Date: 04/11/2024

Re: **Overhanging Sill Plate**
Location: The Farm at Neill's Creek - 481 Winding Creek Dr. (Lillington, NC)
JDS Project No.: RDU2403784
Date of Inspection: 04/11/2024

**1 MONO SLAB FOUNDATION PLAN**  
SCALE: 1/8"=1'-0"

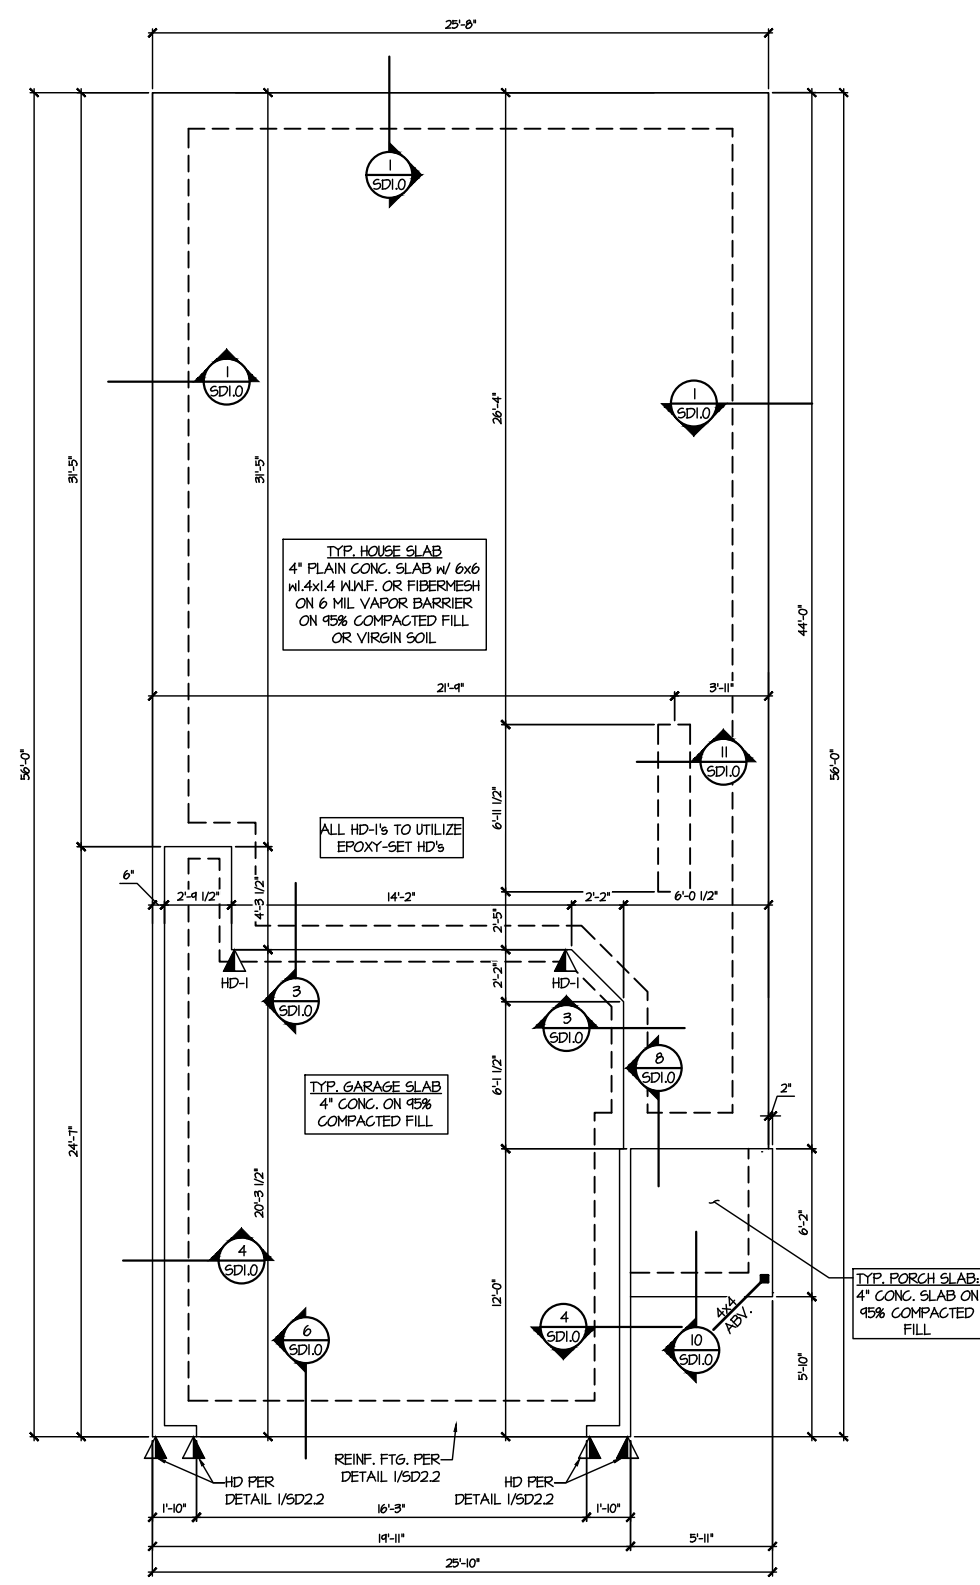
The right garage wall overhangs the monolithic slab foundation at the right side common with the front porch by 1" – 1 1/4".

Based on our onsite observations and review, install an additional full height wall stud to each existing stud for the length of the overhang of the wall and attach with (2) rows of 10d nails 6" on center.
